WLDC RESPONSE TO EXAMINING AUTHORITY'S QUESTIONS (ExQ1) TILLBRIDGE SOLAR PROJECT

Question 1.1.5 - Summary Table of Key Planning Impacts

FIGURE NUMBER
 Figure 4-6

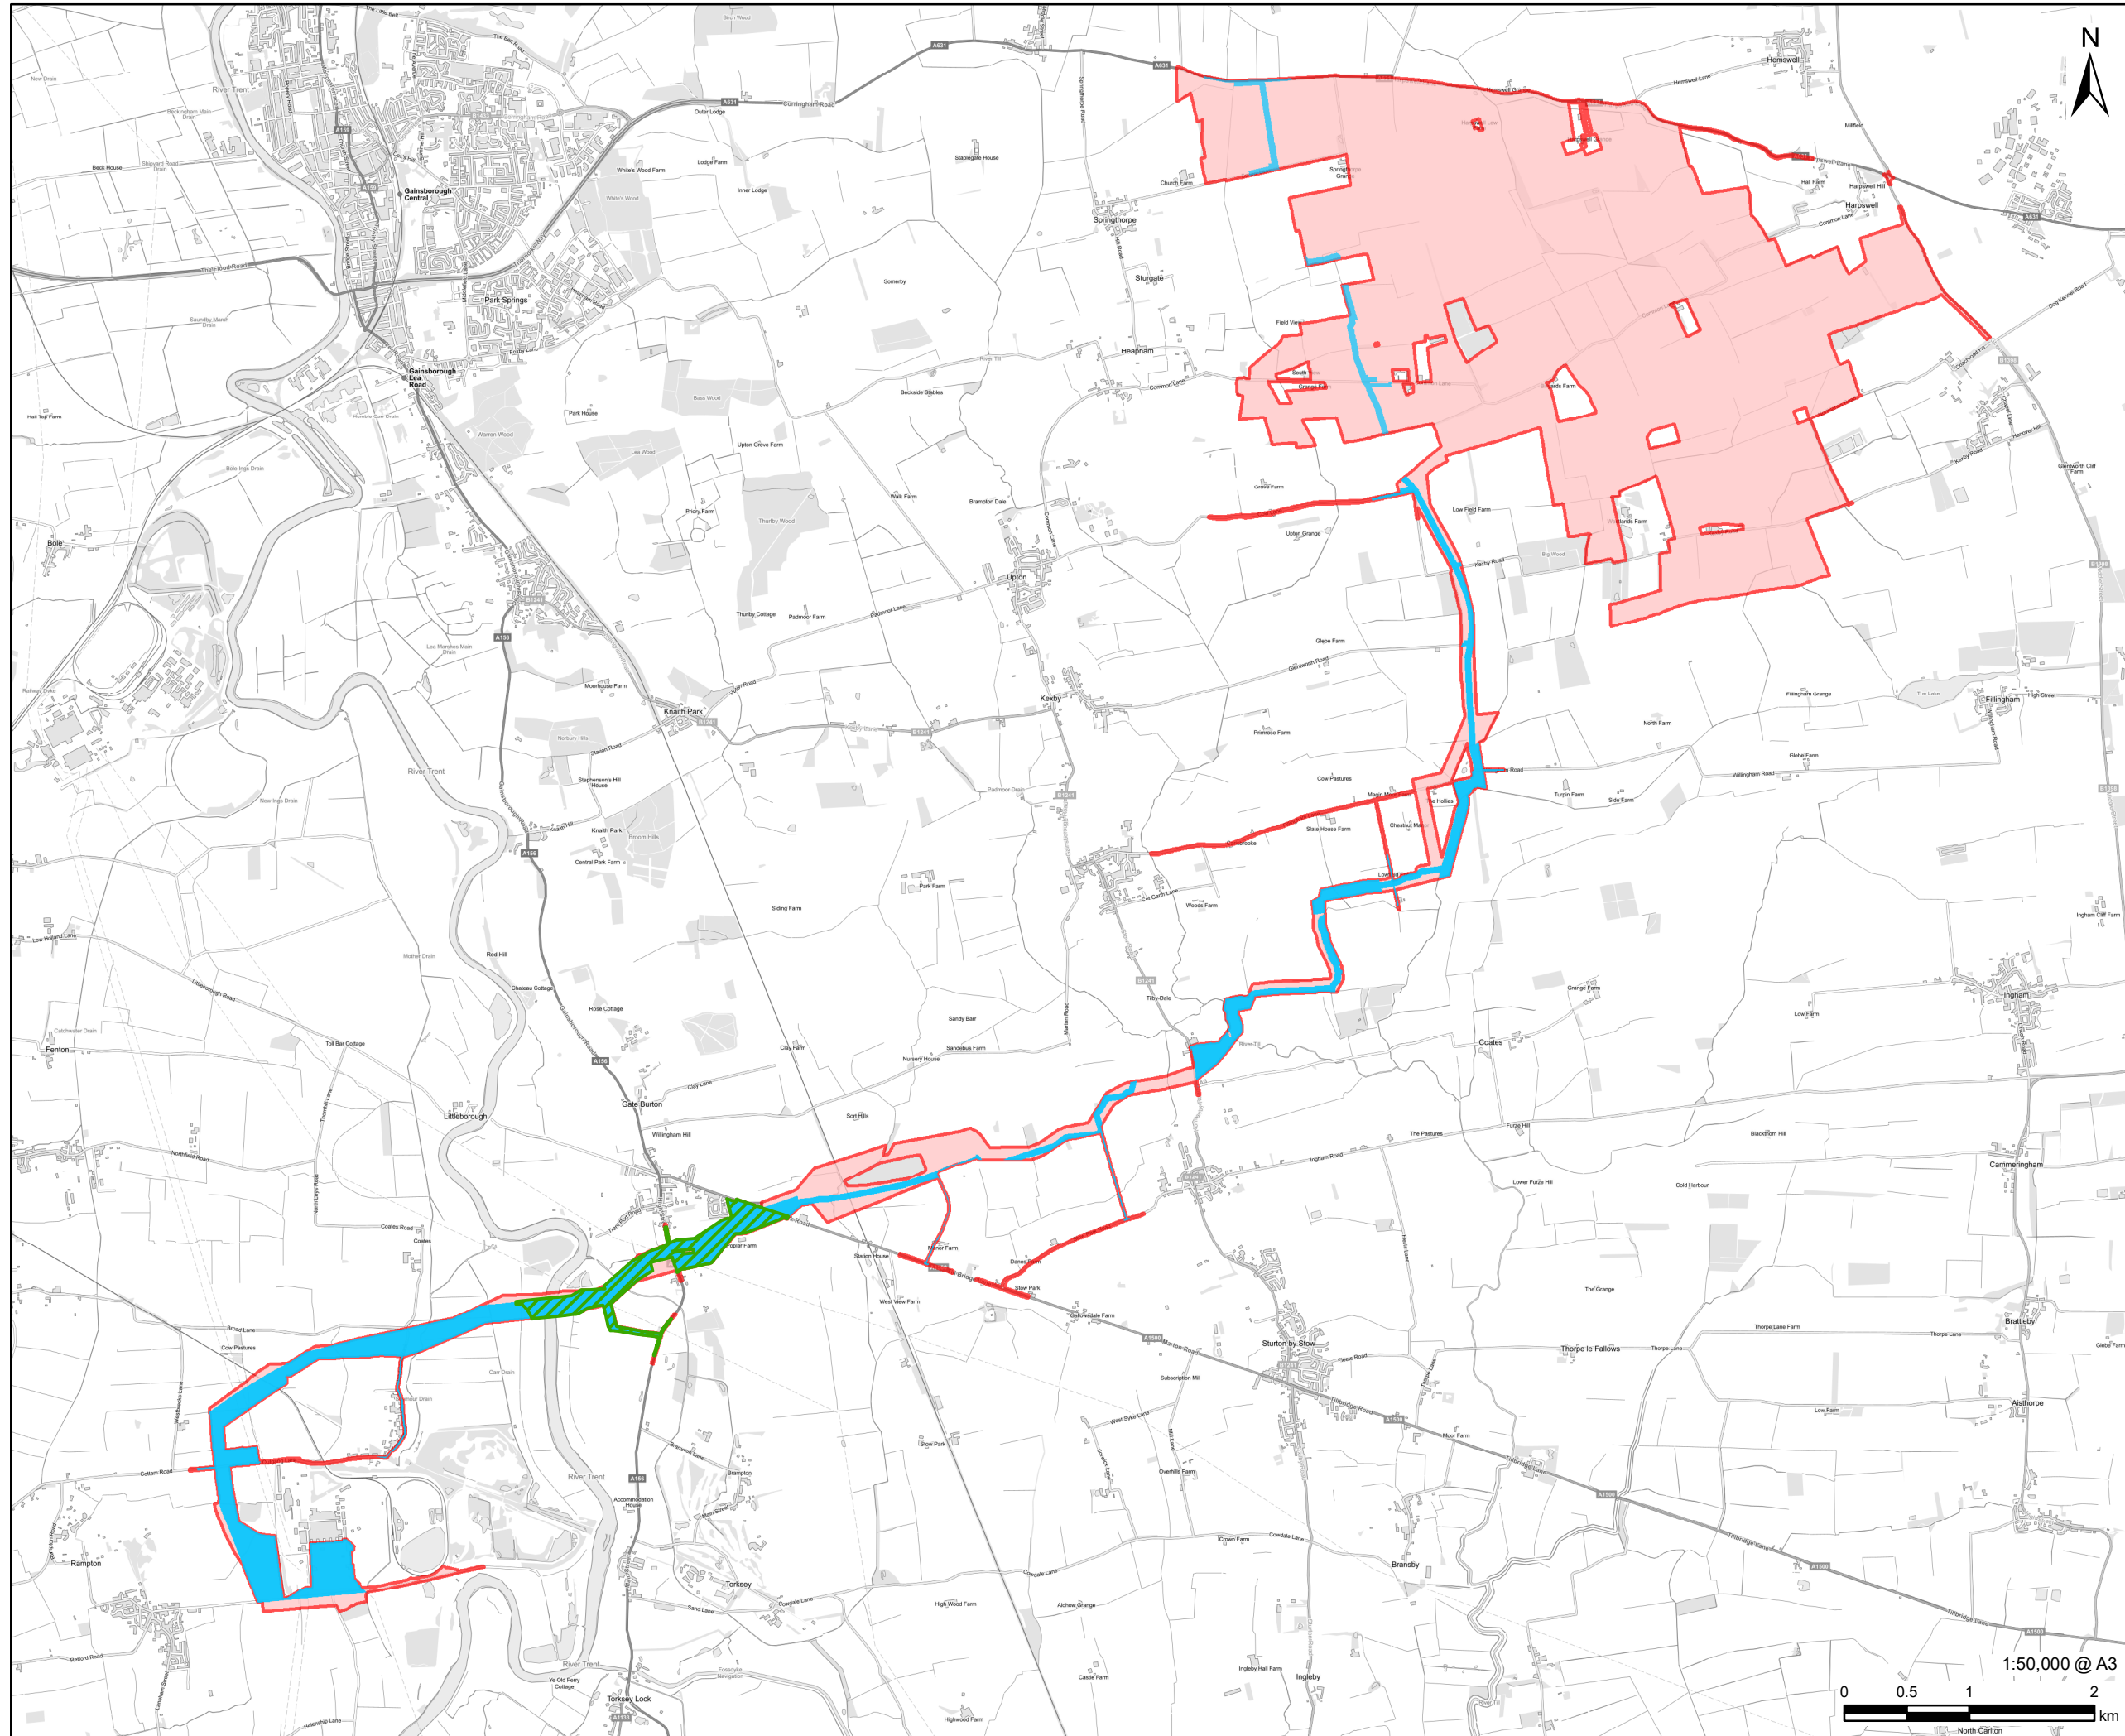
Soils and Agriculture	WLDC would welcome clarification on the approach to soil surveys in the Cable Route Corridor. It appears to WLDC that the Corridor has not been subject to a soil survey.	Construction Operation Decommissioning
Soils and Agriculture	The assessment of the effects on farming circumstances is unsatisfactory to WLDC as there is insufficient baseline information for a detailed assessment to be made, and an established methodology has not been used.	Construction Operation Decommissioning
Soils and Agriculture	It is not clear why information from certain farm businesses affected by the Scheme have not been included in the assessment.	Construction Operation Decommissioning

FIGURE NUMBER
Figure 13-1

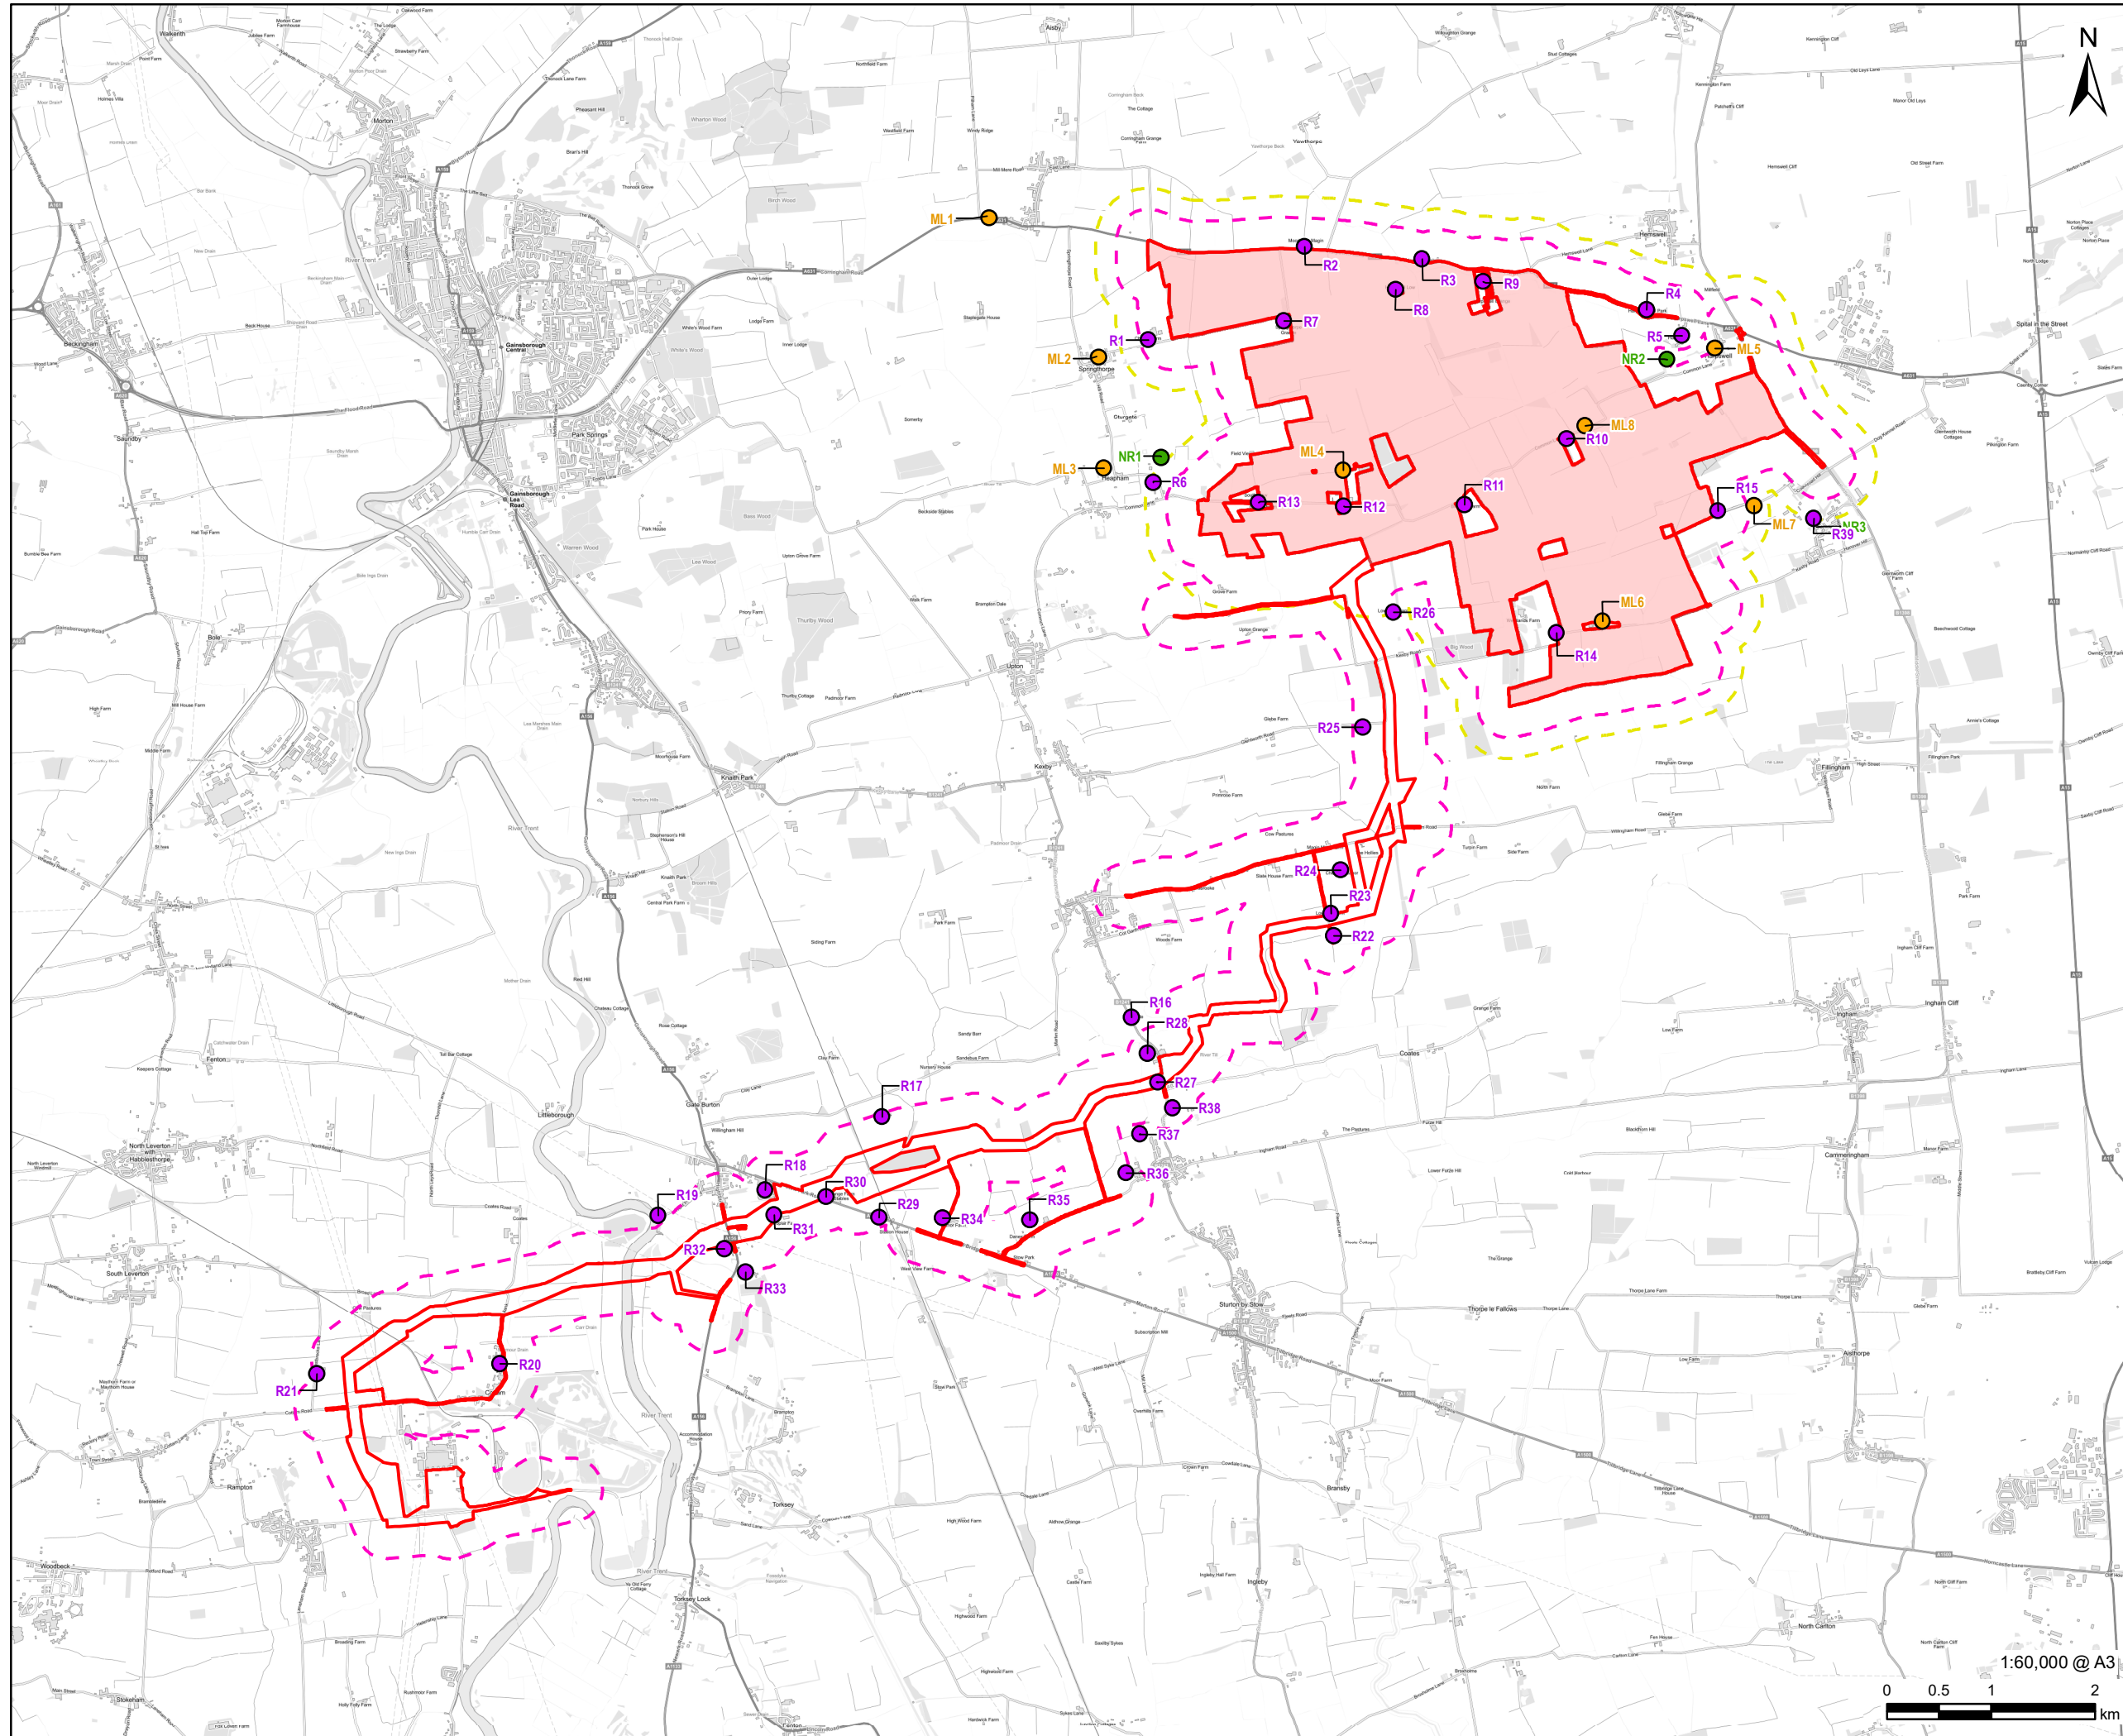
Noise and Vibration	<p>Clarification on the conditions that triggered the removal of noise data would be welcomed.</p>	Construction Operation Decommissioning
Noise and Vibration	<p>It appears that no construction vibration impacts are presented. Clarification of the reason why is required (e.g. distances from receptors are sufficient).</p>	Construction
Water Environment	<p>There are several impacts on the water environment as a result of the Scheme. This includes increased flood risk, pollution from surface water runoff, increased water volume discharge and inappropriate wastewater disposal, among others.</p>	Operation
Water Environment	<p>The risk of flooding and drainage remain key concerns for WLDC. The preparation and implementation of mitigation measures to a high quality is required.</p>	Operation
Ground Conditions	<p>WLDC seeks clarification that the assessment methodology is informed by, and is compliant with, Government and/or DMRB methodologies. If this is not the case, an explanation of the robustness of the approach taken would be welcomed.</p>	Construction Operation Decommissioning
